Rezoning Transportation Analysis

Petition Number: 2024-022

General Location Identifier: 03703102, 03703113

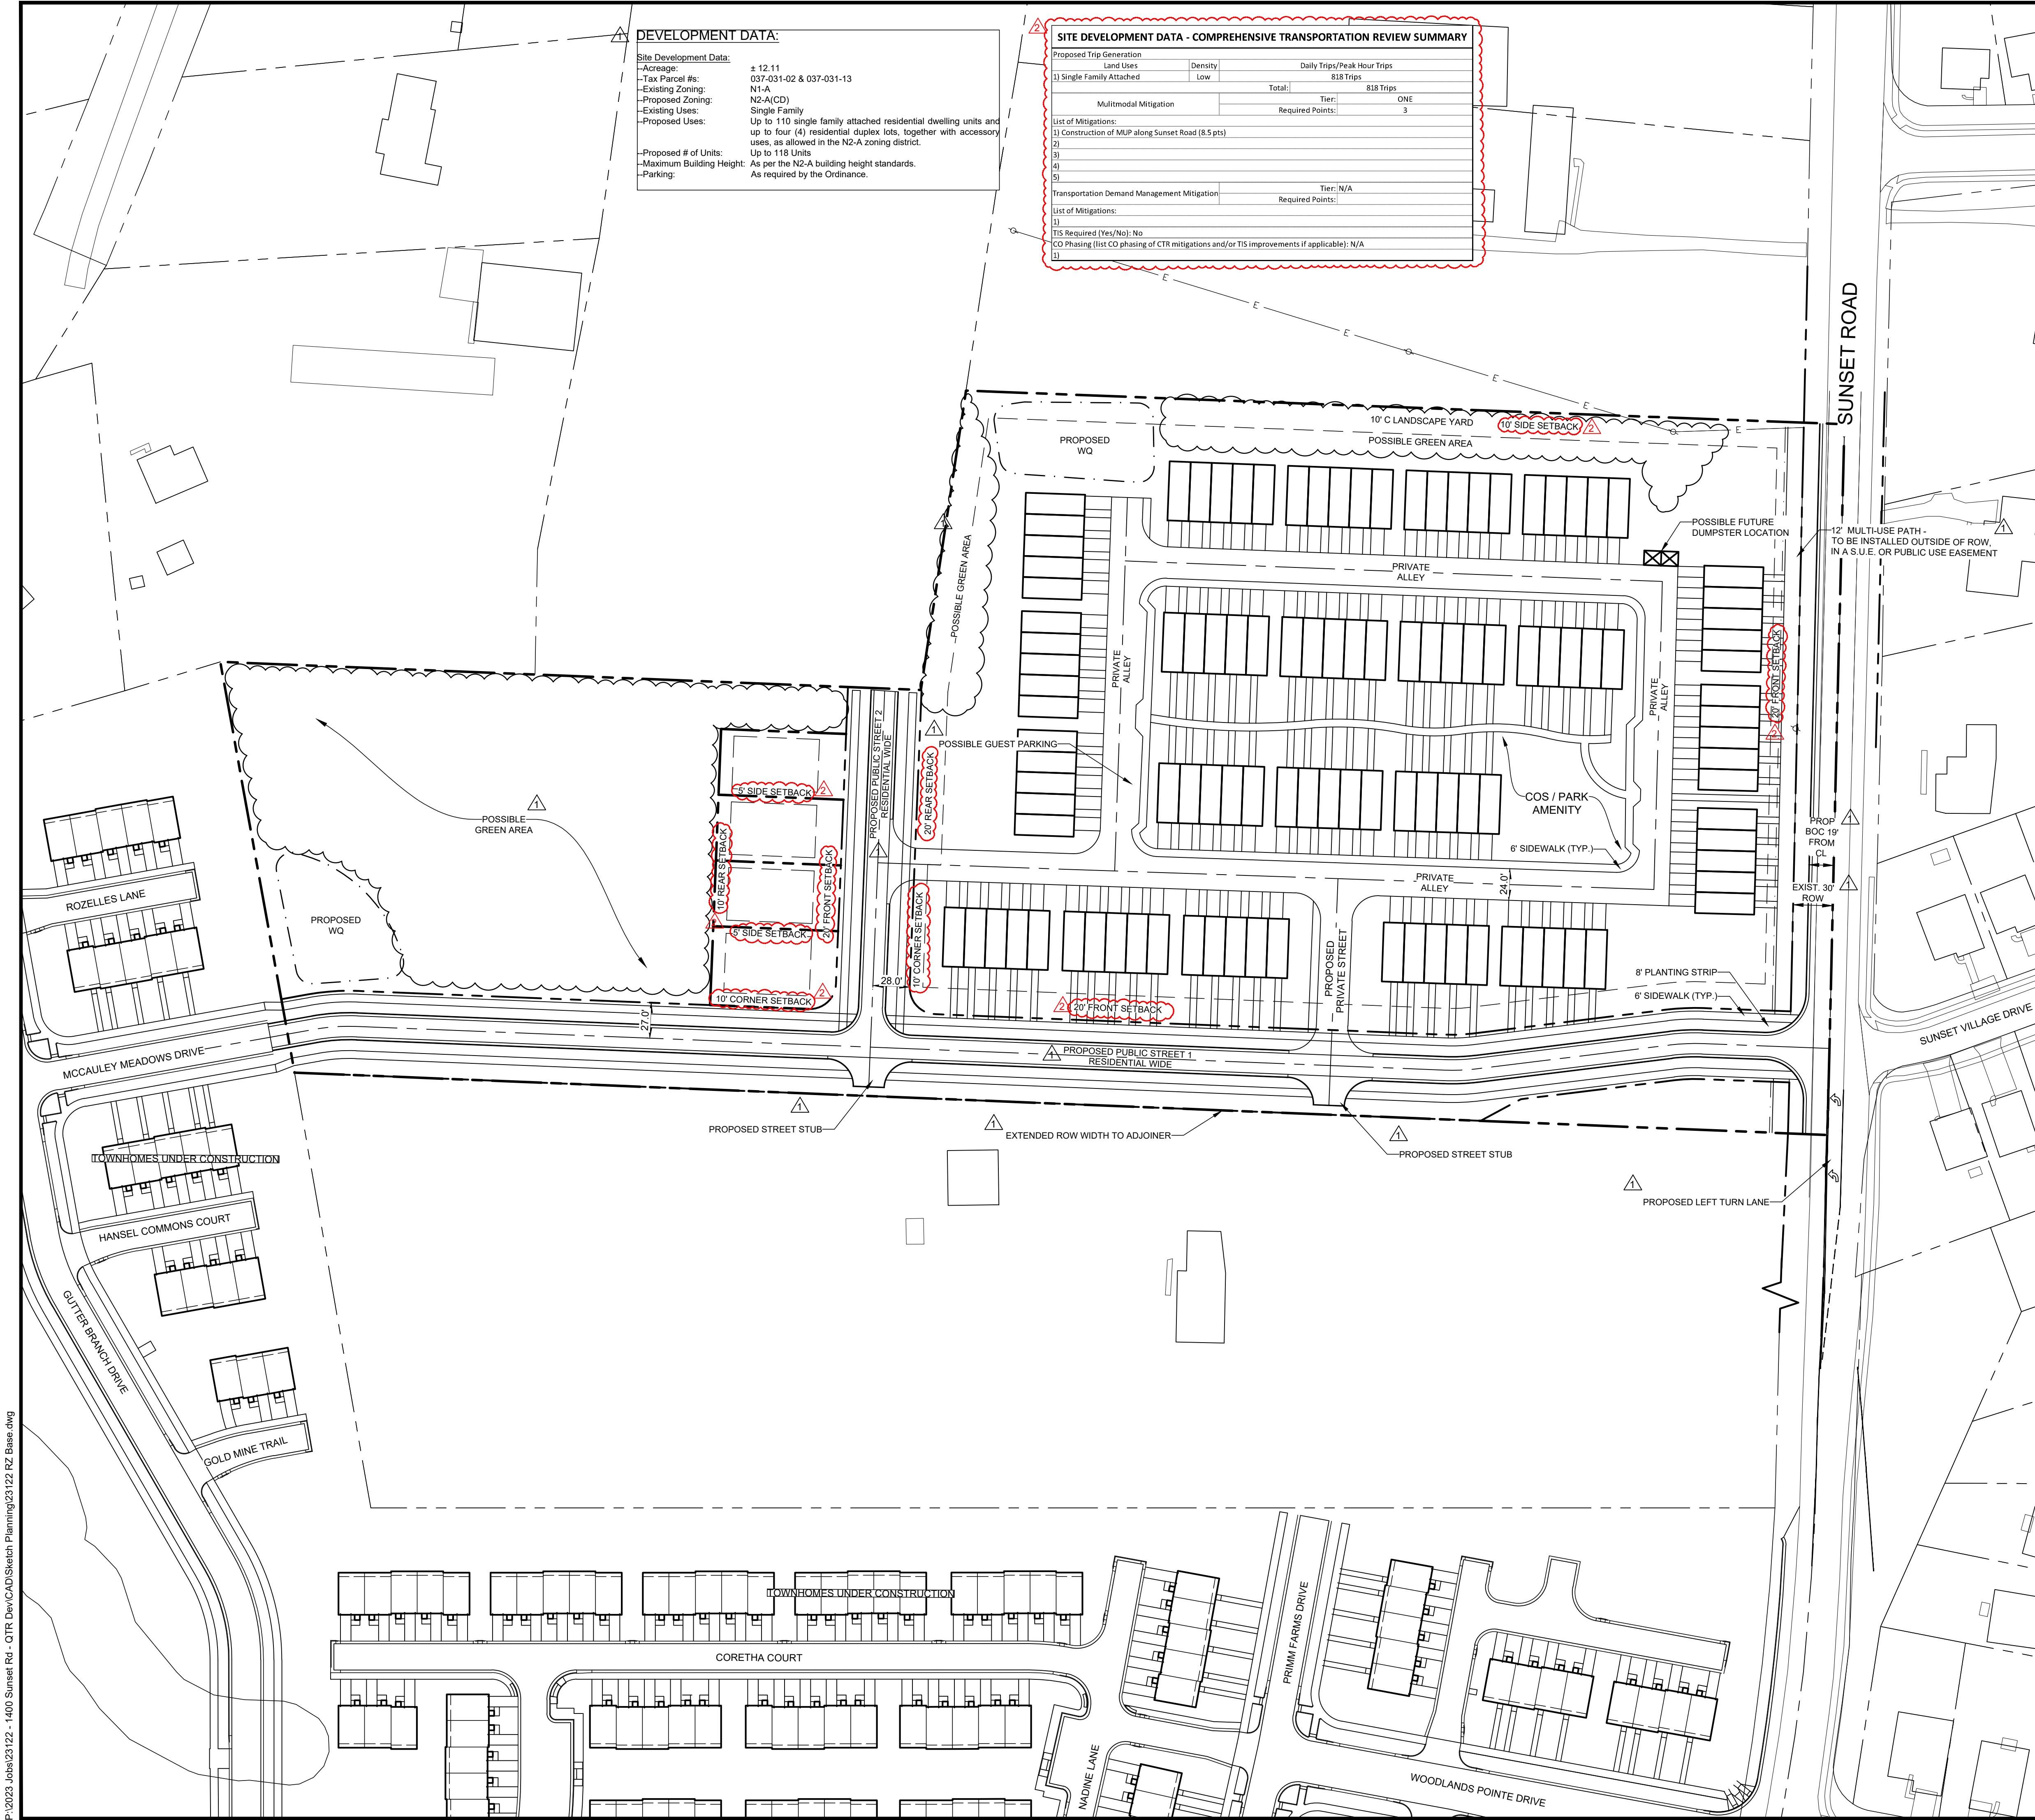
6. **Outstanding Comment 03-27-24:** Revise site plan and conditional note(s) to commit to creating cross-access with the Northern Parcel fronting Sunset Road per Article 31.2 in the UDO.
Outstanding Clarifying Comment 04-24-24: Show proposed cross access with the Northern Parcel at some location along the property line. Per UDO 33.6 the cross-access connection shall have a minimum 20 foot wide two-way paved connection.
